CITY OF ALBUQUERQUE

September 12, 2014

**Re: Smith's #485 Fuel Center
Grading and Drainage Plan
Engineer's Stamp Date 9-5-14 (F18-D057)**

SHEET NO.
C2.1

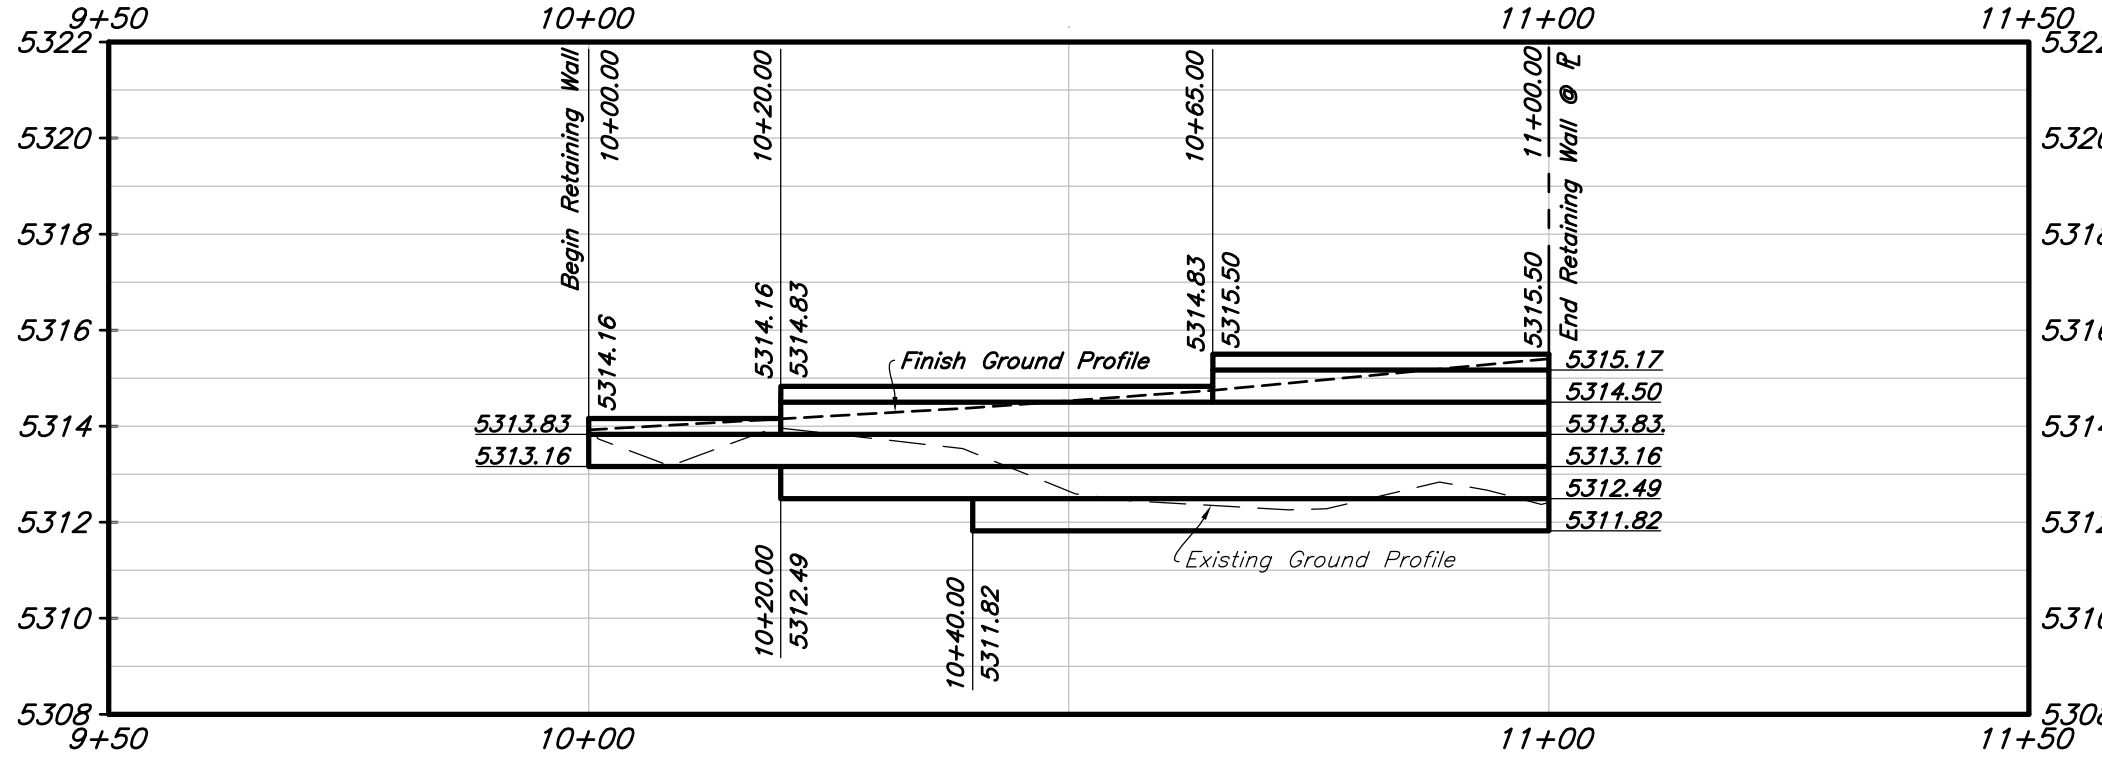
1. There is only a 4.5 inch water block on Louisiana at the entrance to the site. Reasons have been provided for doing this, but it is not acceptable to have public water enter the property without a public drainage easement which is not advisable. Provide an 8 inch water block or demonstrate the water in Louisiana is less than 4.5 inches with an analysis of the upstream drainage basin.
